**From:** Jean Fraser  
**To:** Amanda Schultz  
**CC:** Christina Stacey; Jeff Materazzi  
**Date:** 12/18/2015 4:44 PM  
**Subject:** Conditional approval RE: Permit #2697 - Irving Oil, 2282 Congress St, Portland, ME  
**Attachments:** Building Elevations.pdf; Canopy Signage Layout.pdf; Pylon Sign Drawing.pdf

I am writing to confirm that your request for a waiver of the sign ordinance provisions, in respect of the building signs, canopy signs and one pylon sign near Congress Street, have been reviewed under section 14-526 (d) (8). The Planning Authority has determined:

Drawing file: Submissions / Building Elevations.pdf

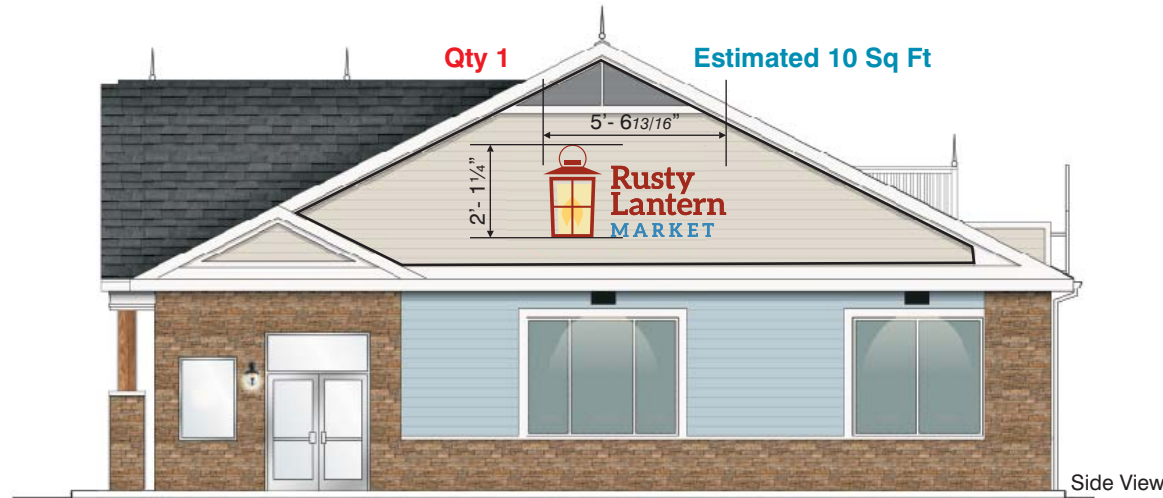
**one pylon sign near Congress Street:** that the proposed pylon sign (plan dated 12.7.2015 as attached) does not meet the waiver criteria for 2 reasons:

it includes advertising (lowest panel) that does not signpost a separate or particular use on the site there is no need for the extra 4 feet in height, which taken together with the thick blue section is over-scaled.

We will grant a waiver for the pylon sign subject to the following conditions:

that the bottom panel is removed (that refers to "save on gas" with card shape) and the remaining upper section is lowered by 2' 2.5" giving a maximum height of 19.8 feet (with no change to the distance of the sign from the ground, which has been reviewed in relation to sightlines). The 19.8 feet represents a waiver being granted for the increase of 1.8 feet above the standard. This waiver reflects the unique characteristics of the site which limit the location of the sign to a short section of the frontage some ways from the rest of the gas station development; and

that although the sketch site plan shows two pylon signs on this site, only one pylon sign has been approved (as outlined above) for the one nearest to Congress Street.
